From: Sarah Burrow <Sarah.Burrow@arun.gov.uk>
Sent: 01 December 2020 10:30
To: Planning.Responses <Planning.Responses@arun.gov.uk>
Cc: Maria Tomalova <Maria.Tomalova@arun.gov.uk>
Subject: RE: Planning Consultation on: BR/234/20/PL

Engineers Comments Regarding Surface Water Drainage

Application No: BR/234/20/PL
Registered: 16th October 2020
Site Address: Aronel Cottage Nursing Home 5-11 Highfield Road Bognor Regis PO22 8BQ
Grid Reference: 493725 99887
Description of Works: Three storey side extension comprised of twenty nursing units linked to the existing nursing home building. This site is in CIL Zone 4 (Zero Rated) as other development.

Drawing Title:
PROPOSED SITE PLAN

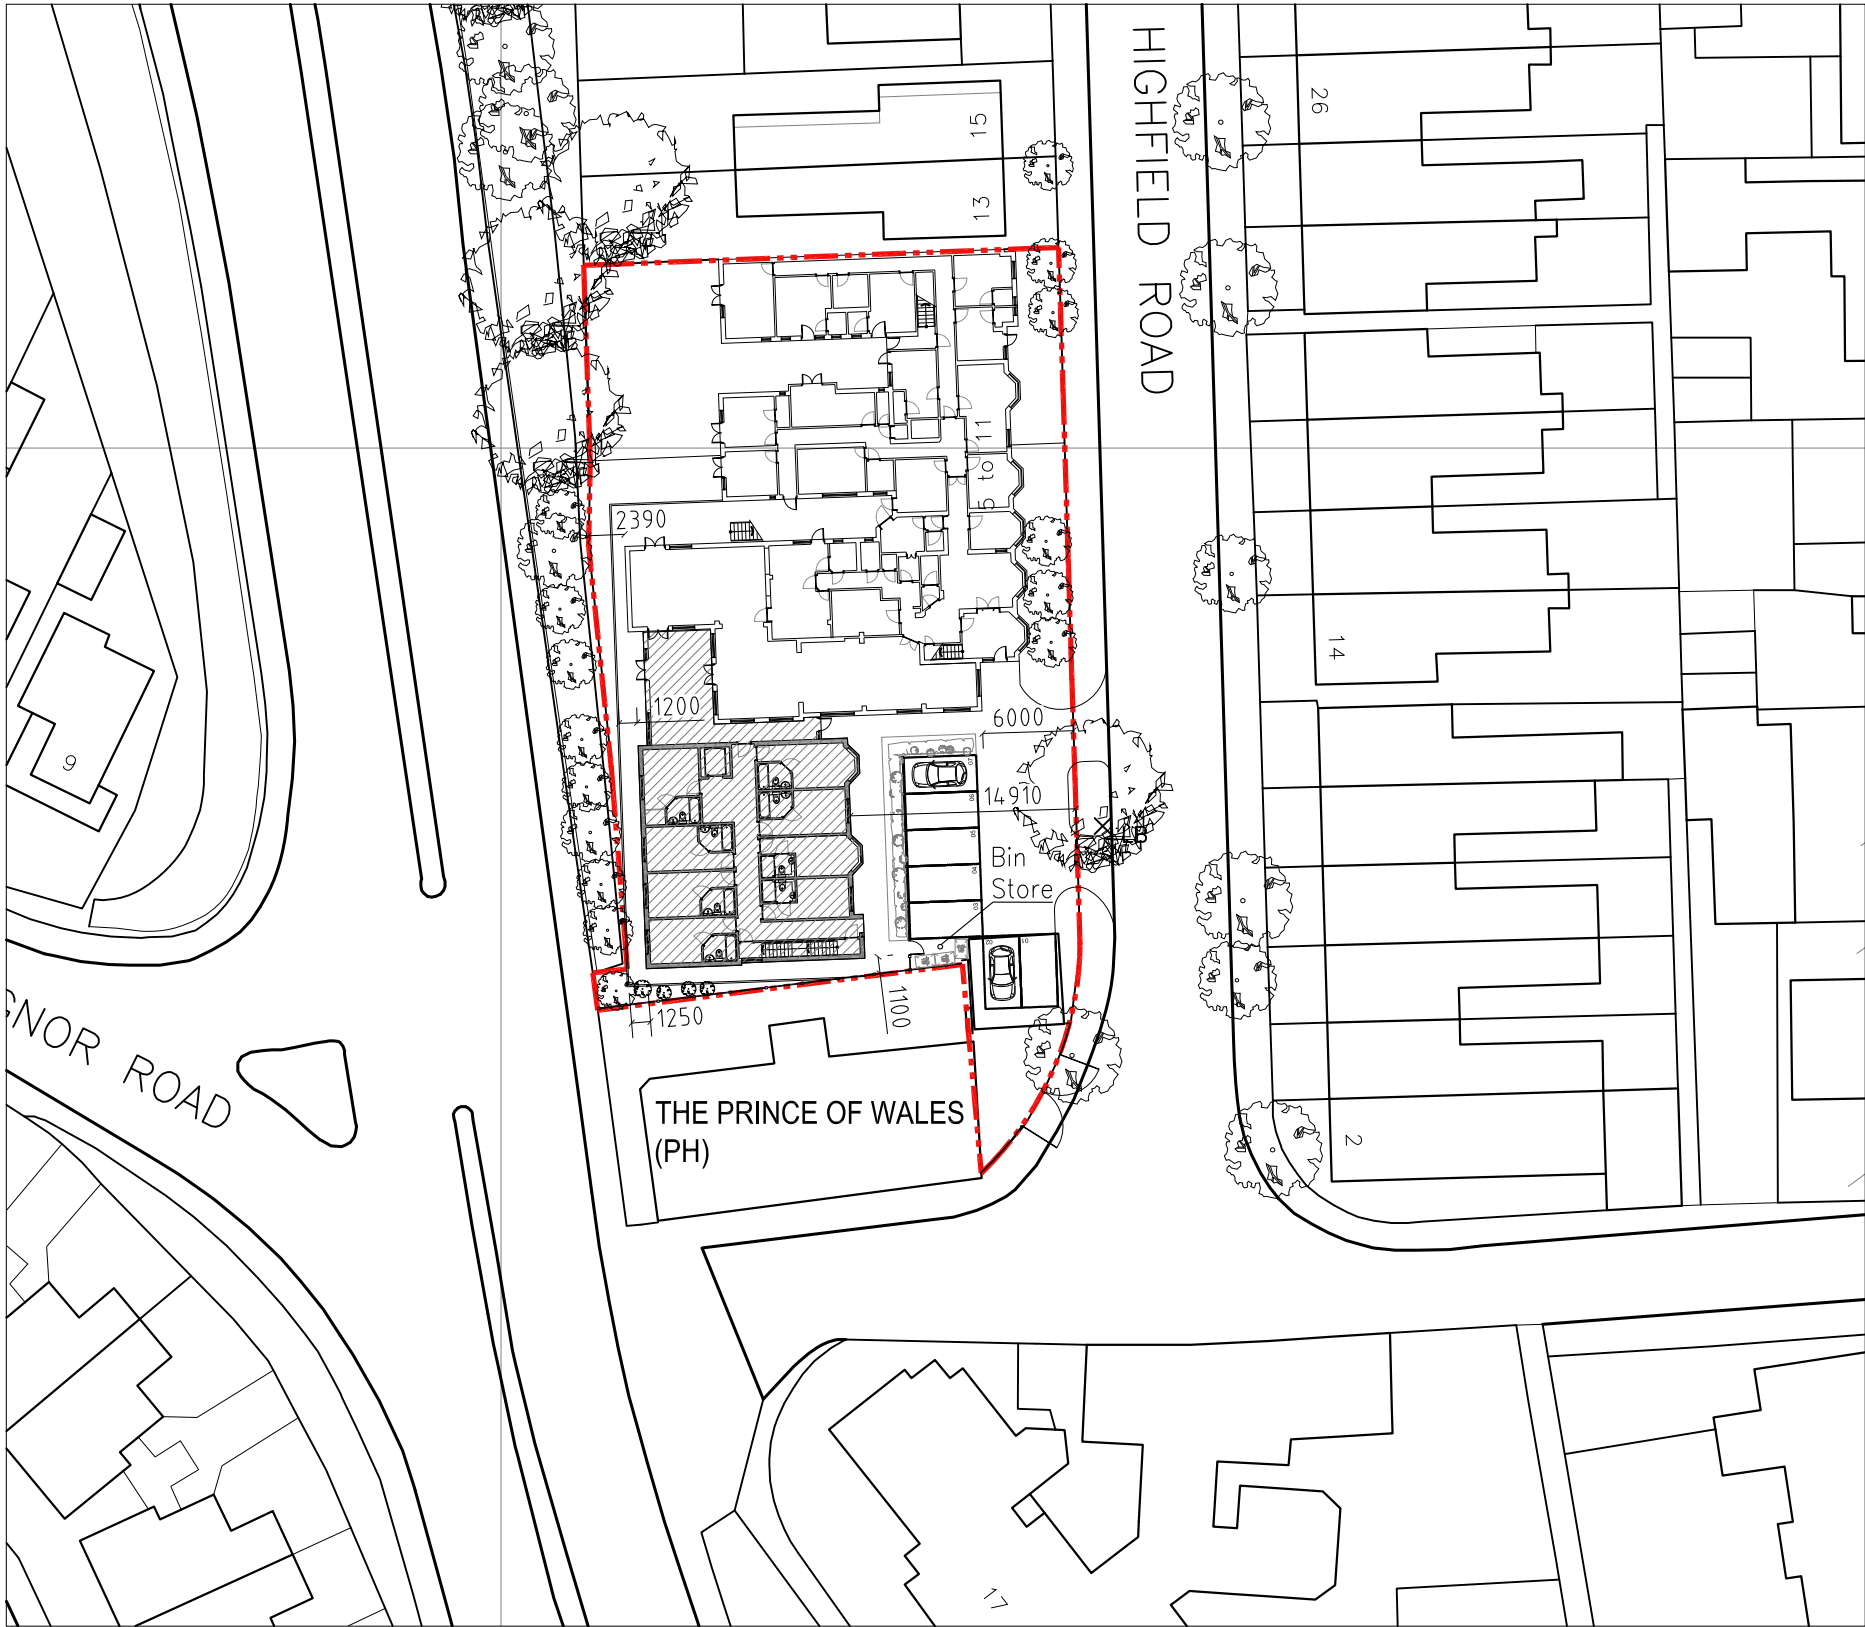
No information regarding surface water drainage has been submitted with this application. The addition of 20 units will restrict the space available for soakaways or attenuation before discharge in to the surface water sewer and there is a risk that the proposed extension will be in the location of existing soakaways. The hierarchy for sustainable drainage must be followed, lack of space is an insufficient excuse for allowing unrestricted flows to the surface water sewer. If you are minded to approve this application please apply standard condition PCENG2 (below) so that the surface water drainage proposal can be thoroughly scrutinised and the risk of flooding elsewhere as a result of this development minimised.

"Development shall not commence, other than works of site survey and investigation, until full details of the proposed surface water drainage scheme have been submitted to and approved in writing by the Local Planning Authority. The design should follow the hierarchy of preference for different types of surface water drainage disposal systems as set out in Approved Document H of the Building Regulations, and the recommendations of the SuDS Manual produced by CIRIA. Winter groundwater monitoring to establish highest annual ground water levels and winter Percolation testing to BRE 365, or similar approved, will be required to support the design of any Infiltration drainage. No building / No part of the extended building shall be occupied until the complete surface water drainage

system serving the property has been implemented in accordance with the agreed details and the details so agreed shall be maintained in good working order in perpetuity."
